CONSULTEE RESPONSE (Council's Arboriculturist)

Reference: **AL/31/22/PL**

Proposal: Demolition of existing building and erection of 4 no. houses with associated access, landscaping, parking and associated works. This site falls within Strategic Site SD5, CIL Zone 1 (zero rated).

Location: Ryefields Farmhouse, Oak Tree Lane, Woodgate, PO20 3GU

VISIBILITY SPLAYS AT ACCESS
2M X 23M AND 2M X 15M

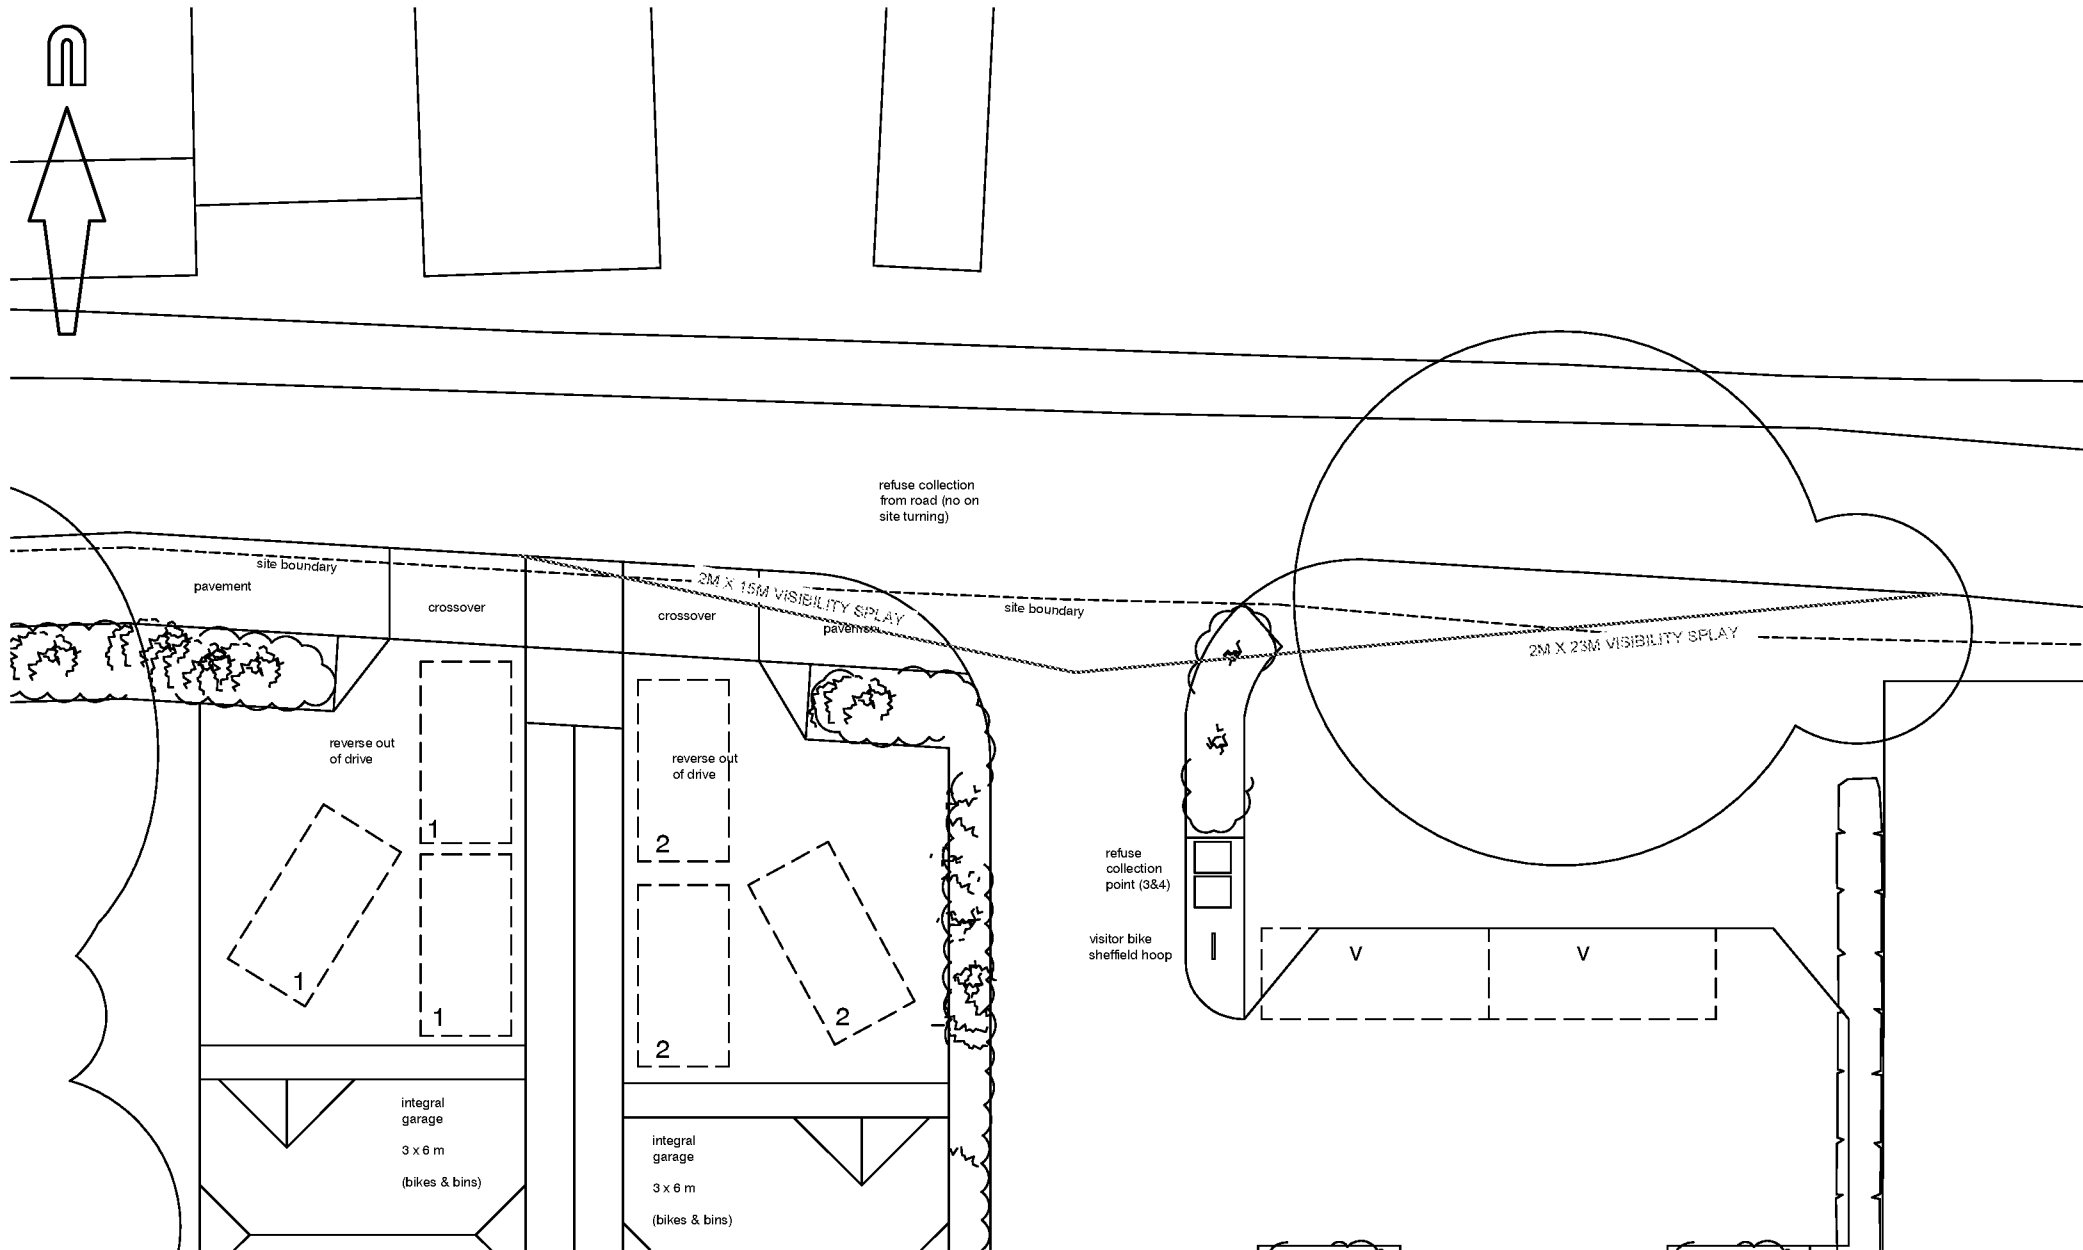
Firstly, I am concerned that by implementing the (WSCC Highway Authority – suggested condition 2) required vehicle sightlines of 2 x 23metres looking east from shared access to plots 3 & 4; it may not be possible to retain T15 (see screenshot below with approximate sightline shown as red line).

The proposals as submitted could be supported in arboricultural terms, although first it is necessary to secure written confirmation that any off-site highway requirement/improvement will not occur within the RPA or crown spread of T15.

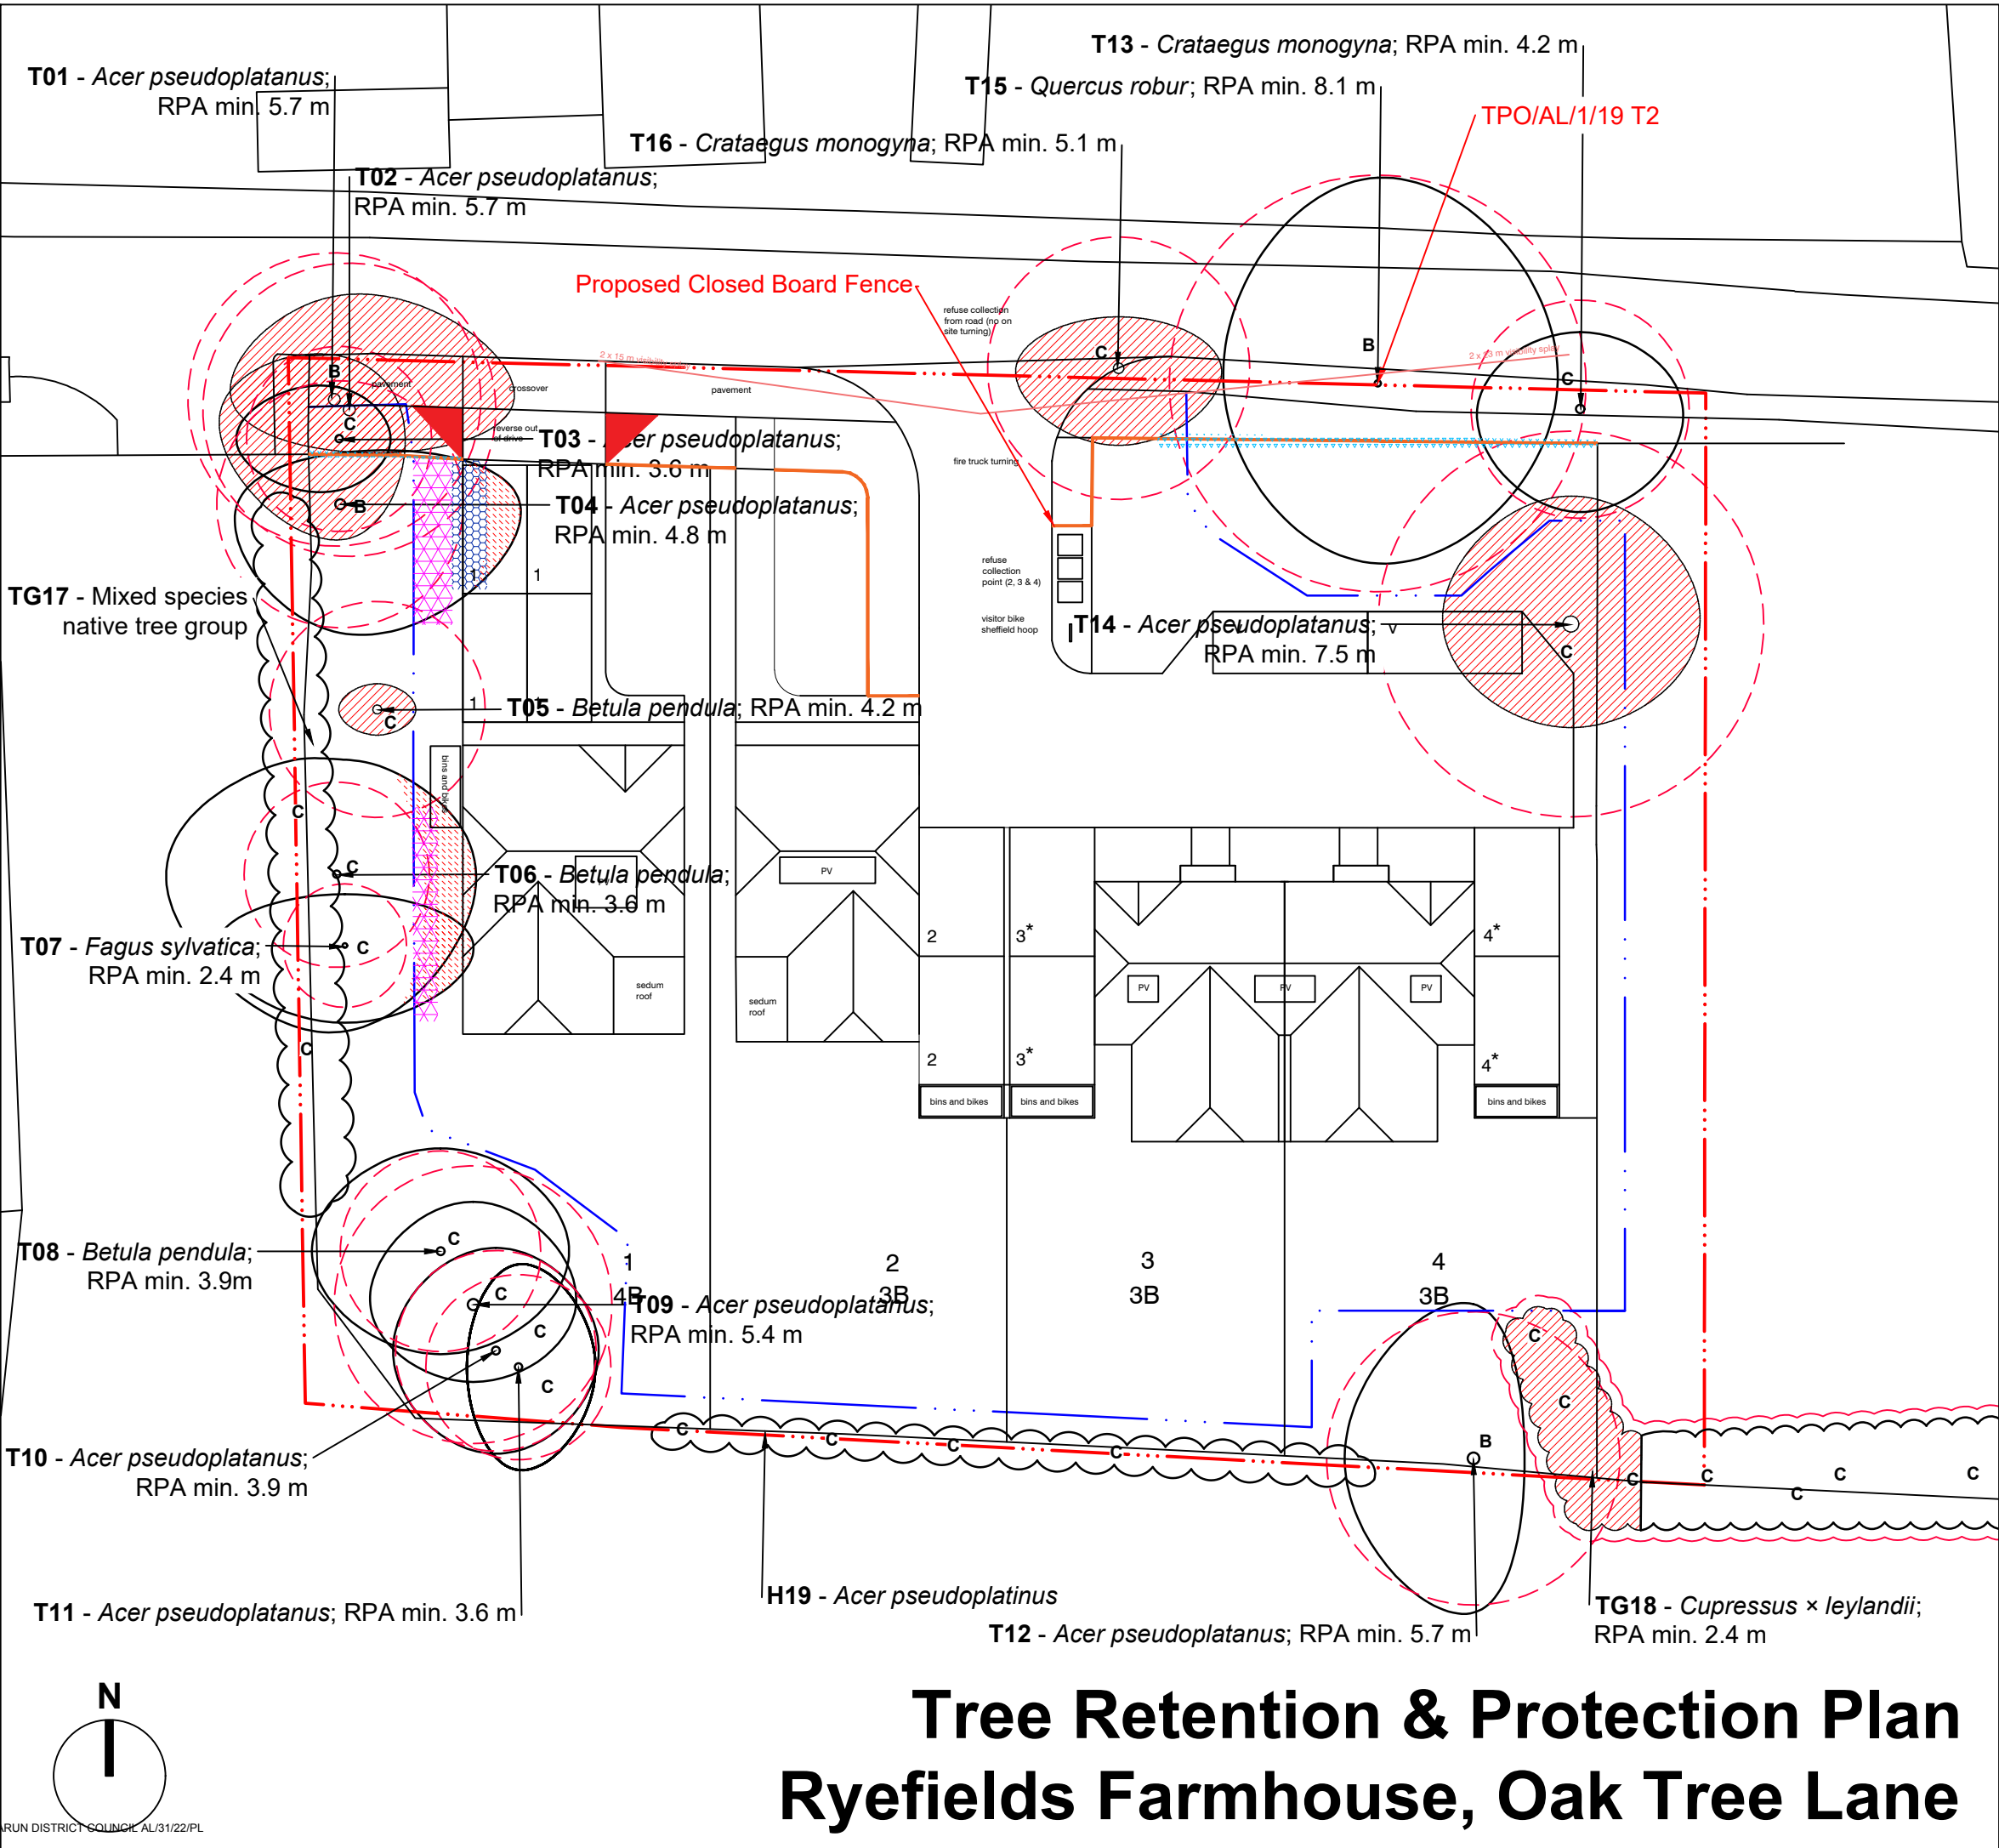
Secondly, there is no explicit mention of track enhancement so we might assume that no RPA interference of T15 will occur, however, any upgrade in construction and/or track-widening could inflict serious damage if not controlled by planning condition.

I have considered the proposed routes for surface and foul water drainage. It appears that attenuation tank and associated apparatus will be located within the RPA of Category B sycamore (T12). If RPA intrusion is significant and likely to be damaging then a revision should be encouraged to prevent further loss of maturing tree canopy from the site and account for its high growth potential. Importantly we await approval from our Drainage Engineer on the proposed strategy. These fundamental elements of the design ought to be addressed to our satisfaction in association with layout proposals, so that we are not subsequently held hostage to flood mitigation measures which could then impact heavily on retained trees.

Before the site is occupied or any machinery is introduced to the site or demolition work or construction work or alterations to existing ground levels takes place a **PRE-COMMENCEMENT Site Meeting** is to take place between the Planning Authority's Tree Officer and the Arboricultural Expert representing the site owner(s) – at this meeting all protective fencing and ground protection measures will be inspected to verify they are 'Fit for Purpose' as required under British Standard 5837:2012 and have been erected and positioned exactly as shown on the **Tree Retention & Protection Plan, LLD2289-ARB-DWG-002, Rev 02**.
